Your Ref
BE/104/11/
Our Ref
S/AR/2011/104
Date: 17/10/2011

Proposal: Erection of a detached single garage. Amendments to BE/51/08. (Re-submission following BE/57/11.)
Site: Land Adj. 37 ,The Croft Bognor Regis, PO21 5TH.
BE/104/11/

Proposed New Detached Single Garage
at Land Adjacent to 37 The Croft, Bognor Regis
for Mr R Lailey
Drawing PG04a July 2011 Scale 1:500 / 1:1250
Block Plan and Location Plan

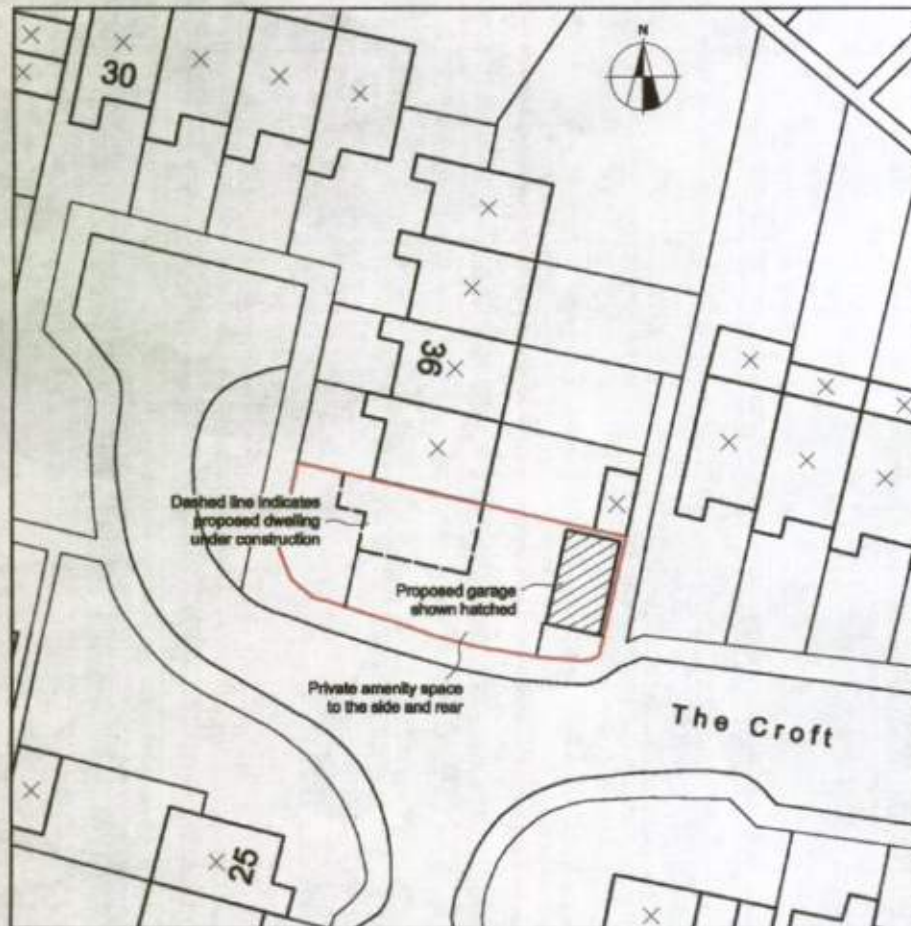
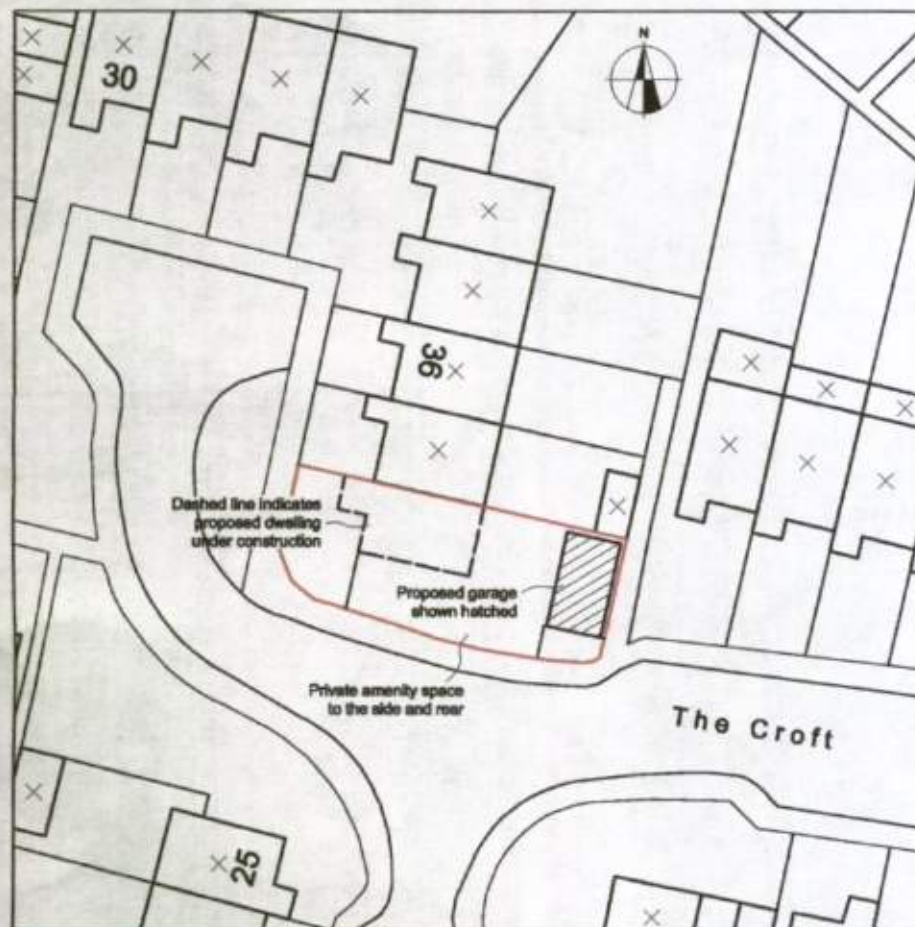
1. No building/construction works within 2.0 metres of the public sewer is permitted, if found to be within 2.0 metres the sewer will have to be diverted or a rejection notice under the Building regulations will be issued.
2. Where within three metres, foundations to be taken down 150mm below the invert level which is approximately 1.2 metres in depth.
3. Location of 150mm diameter surface water sewer is to be confirmed on site before any works commence on site.
4. Care must be taken when working in the area of the public sewer pipeline so that no damage is caused, as any damage will be repaired at the applicant's expense.
